Numbered items are comments raised by Heritage Officer (September 2020).

Comments in **bold** are a summary of discussions from meeting on site with Tim Murphy (Place Services), Graham Keavill (Keavill Heritage Ltd) and Adam Harris (LSH Architects) on Tuesday 20th October 2020.

Job N	Drg N	Rev	Scale	Status	Job
18005	/ SK-84	A	As indicated	FOR INFORMATION	EDGE GROVE SCHOOL - STABLE BLOCK
Date	Director	Author	Check		Drawing
07/10/2020	JA	AH	--		REVIEW OF HERITAGE OFFICER COMMENTS

1 | Ground Floor Plan
1 : 100

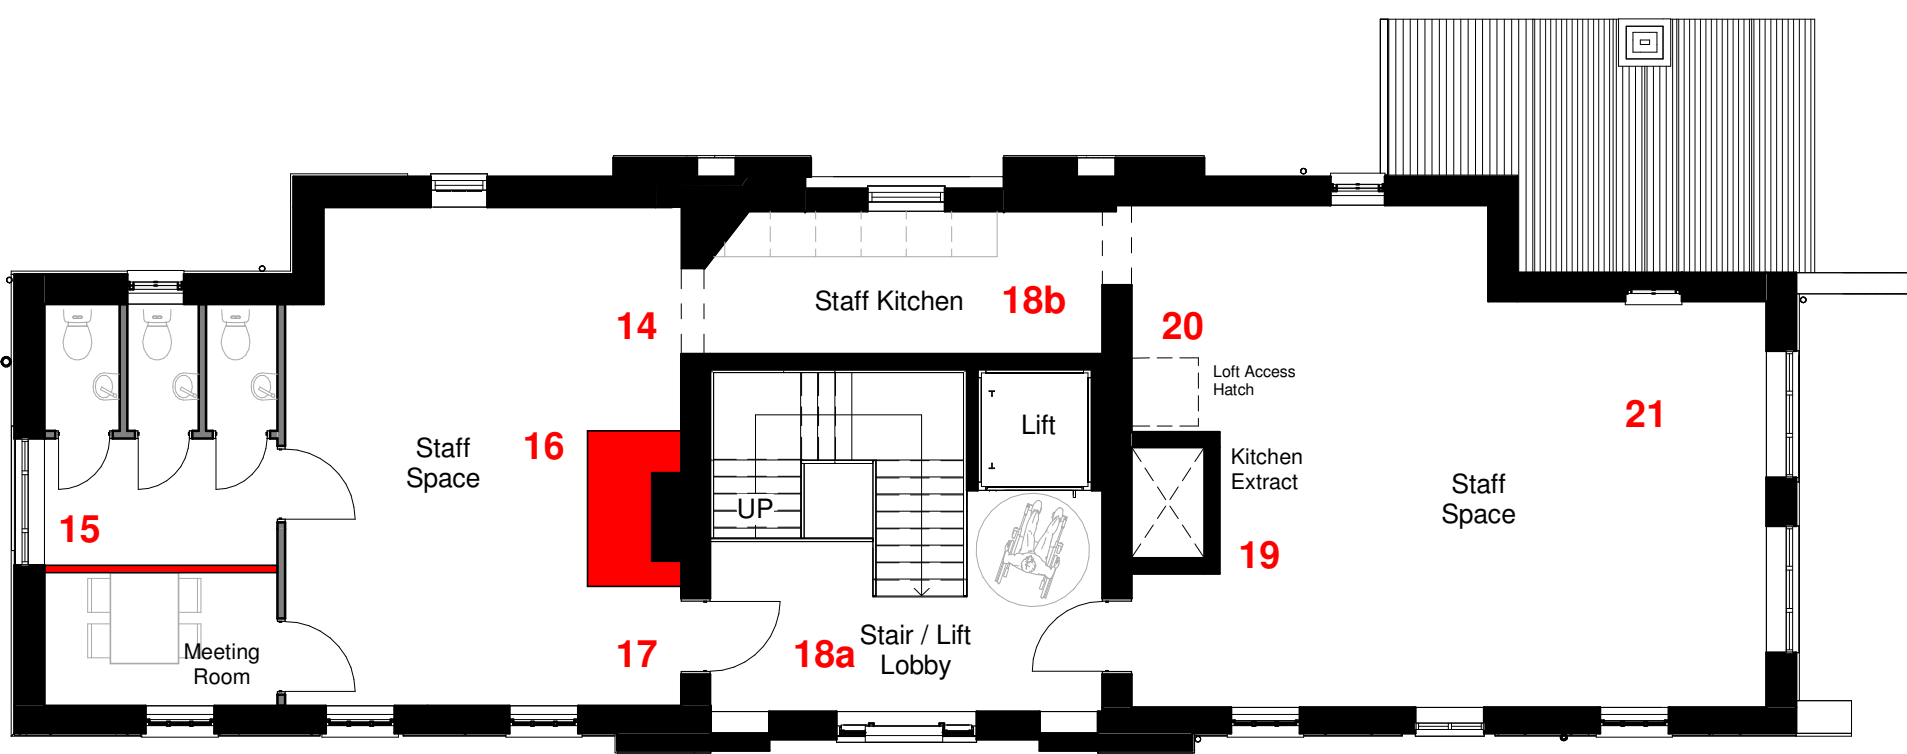
- (1) What age/value is this fabric? Was there a previous opening here to inform location of new opening?  
**GK confirmed there is evidence of existing opening in this location, most likely a window.**

**TM confirmed no objection to opening in this location.**
- (2) What age/value is this fabric? Why is the new wall not on the alignment of the structure?

**TM requested opening up in angled wall to ascertain age of fabric.**  
**GK to advise once photos of opening up received.**
- (3) Was there a previous opening here to inform location of new opening?

- (4) How will match-boarding be retained?  
**TM confirmed no objection to loss of match boarding seeing as stair is to be removed.**
- (5) How will iron column be retained?

**LSH to review how iron column can be retained.**
- (6) Appears all walls are to be lined?  
**LSH to review lining detail. Description / drawing required to avoid condition.**

- (7) What age/value is the ceiling fabric?  
**TM confirmed no objection to stair / lift opening in ceiling fabric in this area. See also Item 18.**
- (8) What age/value is this fabric? Was there a previous opening here to inform location of new opening?

**TM confirmed no objection to opening in this location.**
- (9) What interventions are needed to make this a kitchen? Lining of walls? Extractor fans? Bins? Storage?

**TM confirmed no issue with modern partitions being removed. Highlighted store cupboard wall (9a) which requires further consideration. Opening up in ceiling above store required to review structure. GK to advise once photos of opening up received. LSH to consider retaining wall.**

- (10) How will this structure be encapsulated?  
**Match boarding to be retained within existing office. LSH to consider door position. Either through match boarding (jib door) or through external wall.**

- (11) What age/value is this fabric? Heritage statement notes it wasn't inspected.  
**TM & GK agreed there is no value to this area.**
- (12) What age/value is this fabric? Was there a previous opening here to inform location of new opening? What is the age and significance of boarding?

- (13) What age/value is this fabric? What's the justification for the loss of fabric and divergence from plan form?  
**LSH to consider retention of existing lintel and locked door. To be reviewed in conjunction with item 9a.**

- (14) What age/value is this fabric? How will this relocated stair impact upon fabric and ground floor?  
**TM requested opening up in ceiling void. GK to advise once photos of opening up received.**

**LSH to consider creating suspended floor to create single level if possible.**
- (15) Plans appear to over-board this wall and to subdivide window.  
**LSH to consider amending partition to avoid window.**

- (16) Plans show significant alteration to this area without detail or justification.  
**GK advised there is a significant amount of modern surface treatment. LSH to consider removal of modern elements whilst retaining bread oven stack.**

- (17) How will new stair impact upon fabric both upon ground and first floor? Was there a previous opening in this location?  
**Potential for steps to be removed following Item 14. GK & TM agreed evidence (existing door frame) of existing opening from central classroom.**

- (18) What age/value is this floor?  
**TM confirmed no objection to opening in this location. LSH to consider retention of as much of the existing floor boards in central classroom as possible.**

- (19) What age/value is this fabric? How will extractor impact?  
**TM confirmed no objection to opening in this location.**
- (20) What age/value is this fabric?

- (21) Need to fully explore fabric – even if covered by fittings such as whiteboard.  
**TM raised concerns regarding lining on first floor. LSH to consider requirement for lining.**

- (22) New Item - Removal of existing chimney stack.  
**TM confirmed suitable method statement to be agreed with LPA regarding removal of existing chimney stack.**
